**Consultation Response from KC,
Lead Local Flood Authority**

**2023/93667 Storthes Hall Student Village, Storthes Hall Lane, Kirkburton, Huddersfield, HD8
0WA**

**Date Responded: 28th March 2025
Responding Officer: Paul Farndale
Responding Ref:**

Site Layout Plan - Scale 1:1000

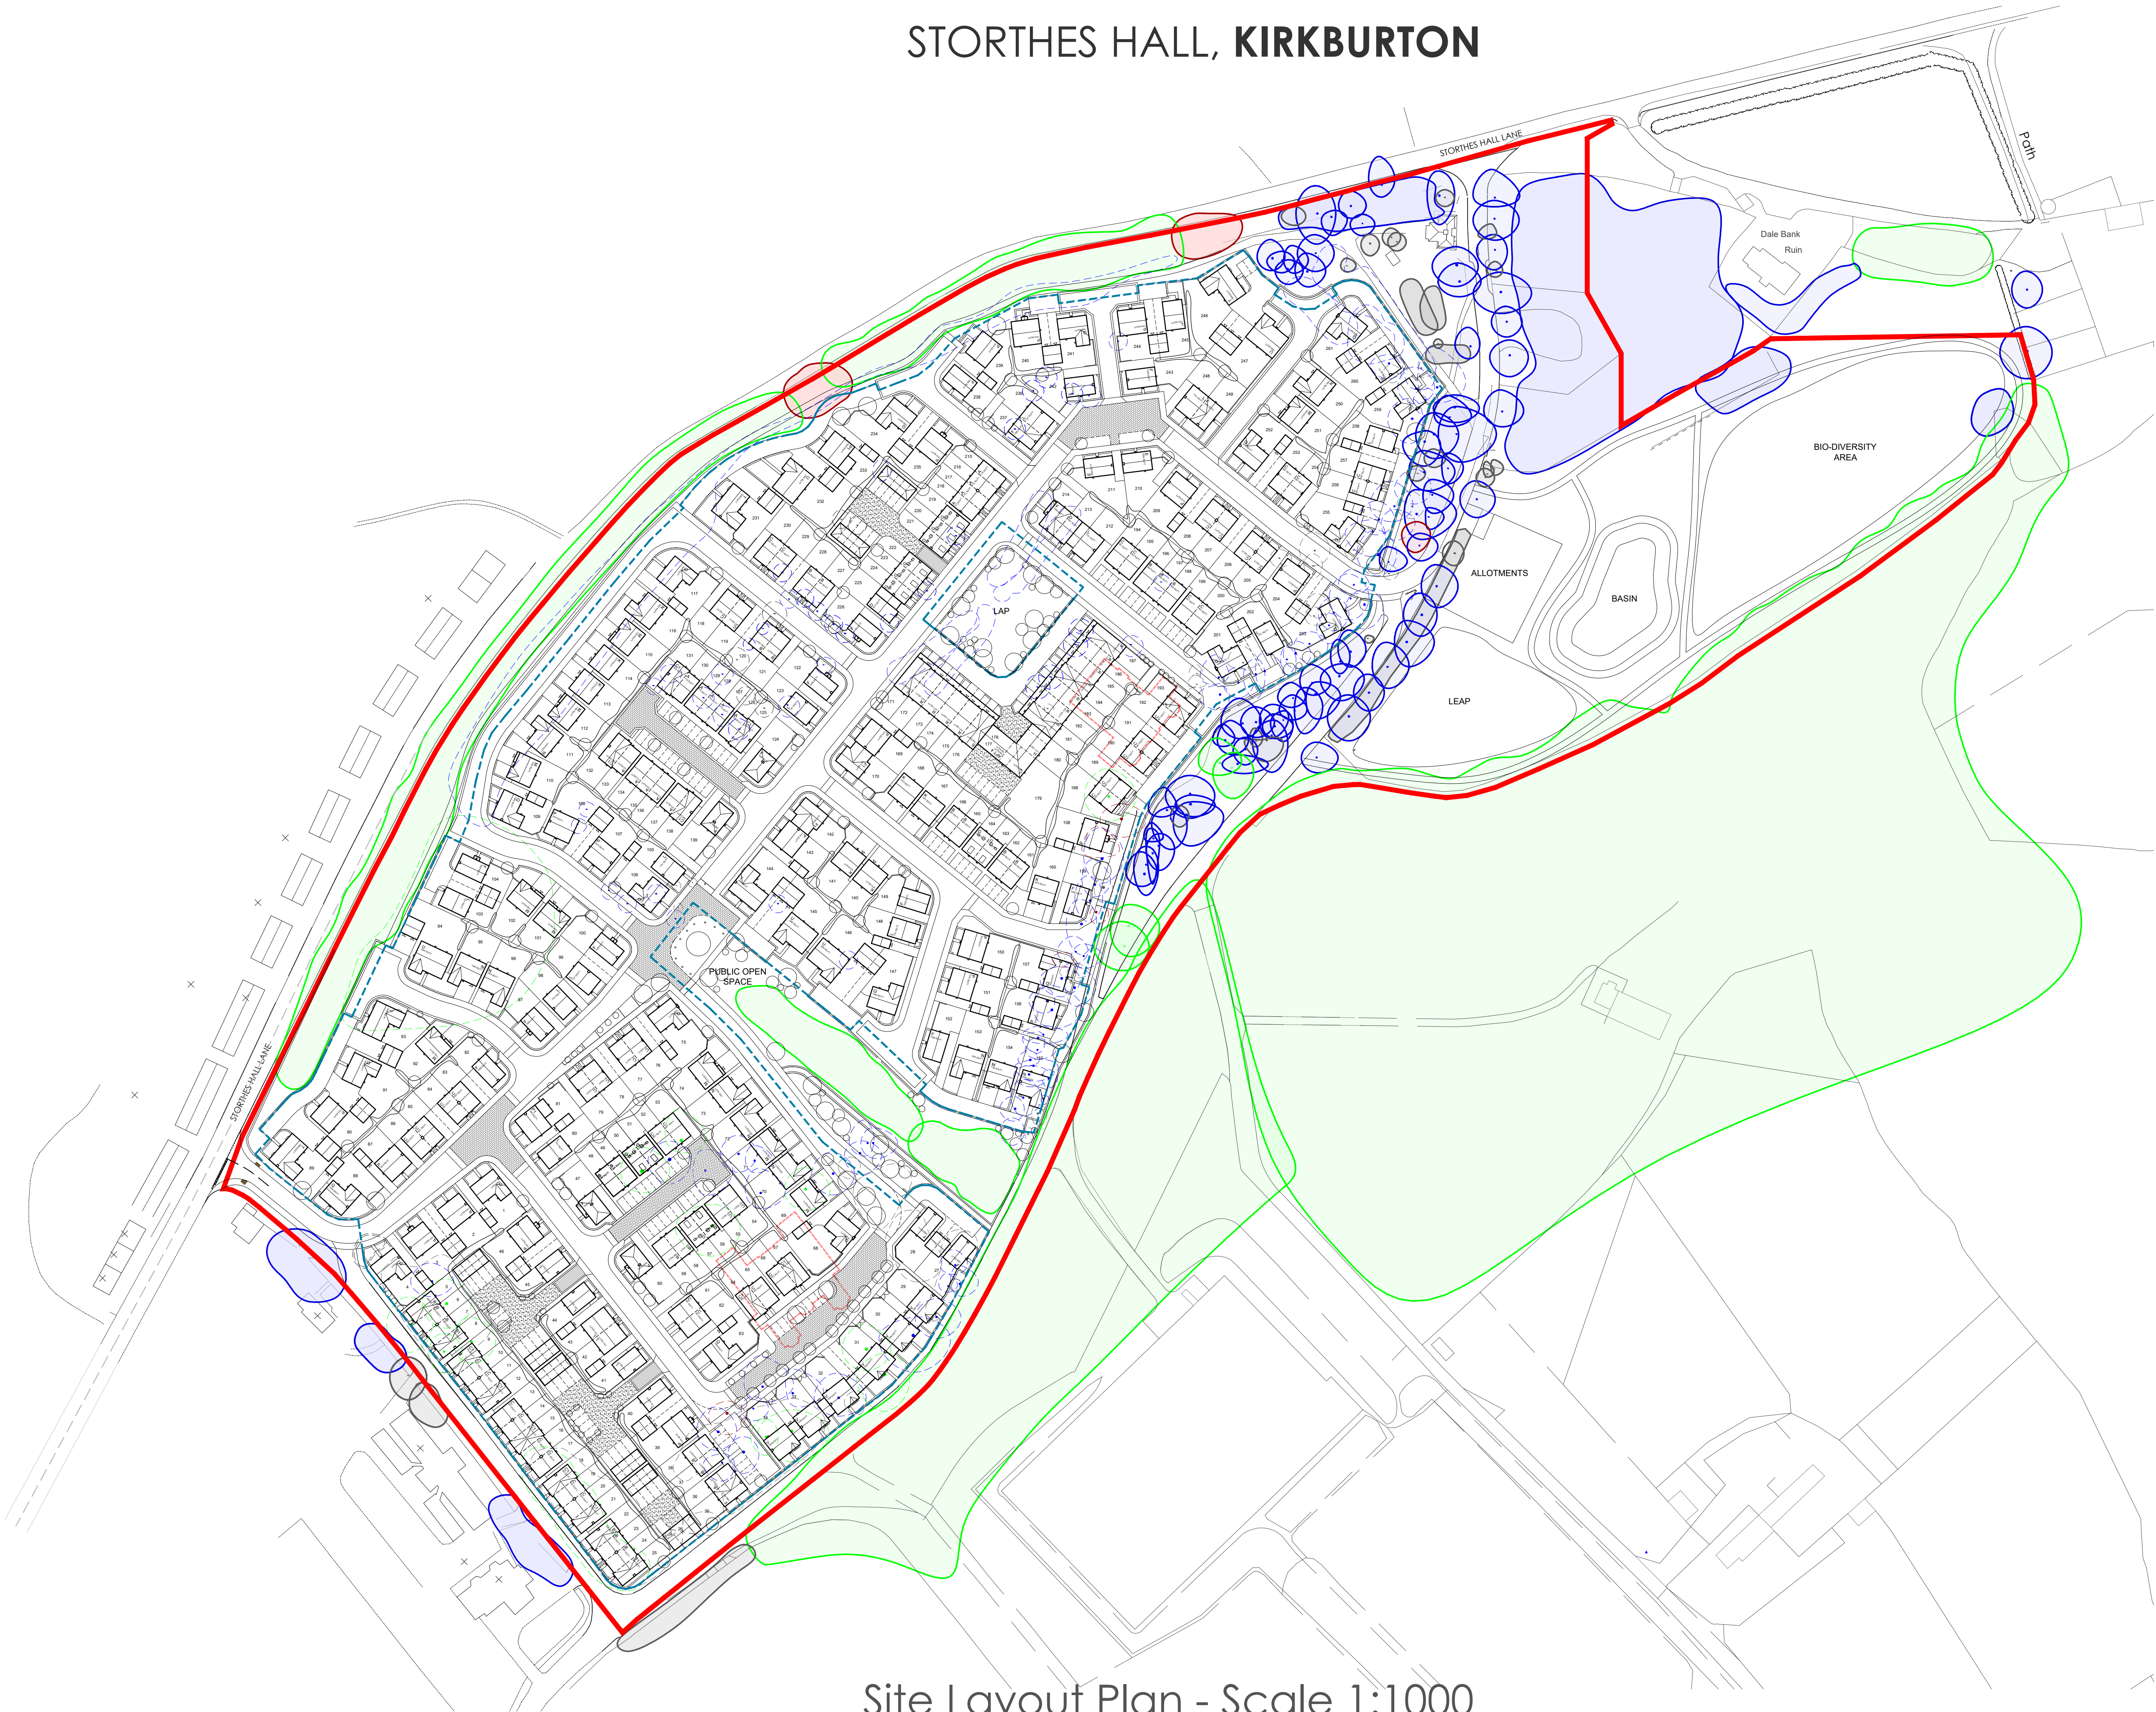
Further to our previous comments, flood routing for the indicative plan would be unacceptable if this was taken forward. Low spots have now been shown for the existing site, and this should influence any proposed layout so that overland flows are conveyed by the road network and through open space. They should not flow through curtilage.

As this is an indicative layout and layout is a reserved matter, flood routing can be conditioned, but the developer should be aware of the issues with the indicative layout which are unacceptable.

DR07 Overland Flows and Flood Routing

The development shall not commence, and reserved matters application not approved, until an assessment of the effects of 1 in 100 year storm events, with an additional allowance for climate change, blockage scenarios, and exceedance events, on drainage infrastructure and surface water run-off pre and post development between the development and the surrounding area, in both directions, has been submitted to and approved in writing by the Local Planning Authority. Flood routing should avoid property curtilage where reasonably practicable and utilise road networks and open space. No part of the development shall be brought into use (dwellings shall not be occupied) until the works comprising the approved scheme have been completed, and such approved scheme shall be retained thereafter.
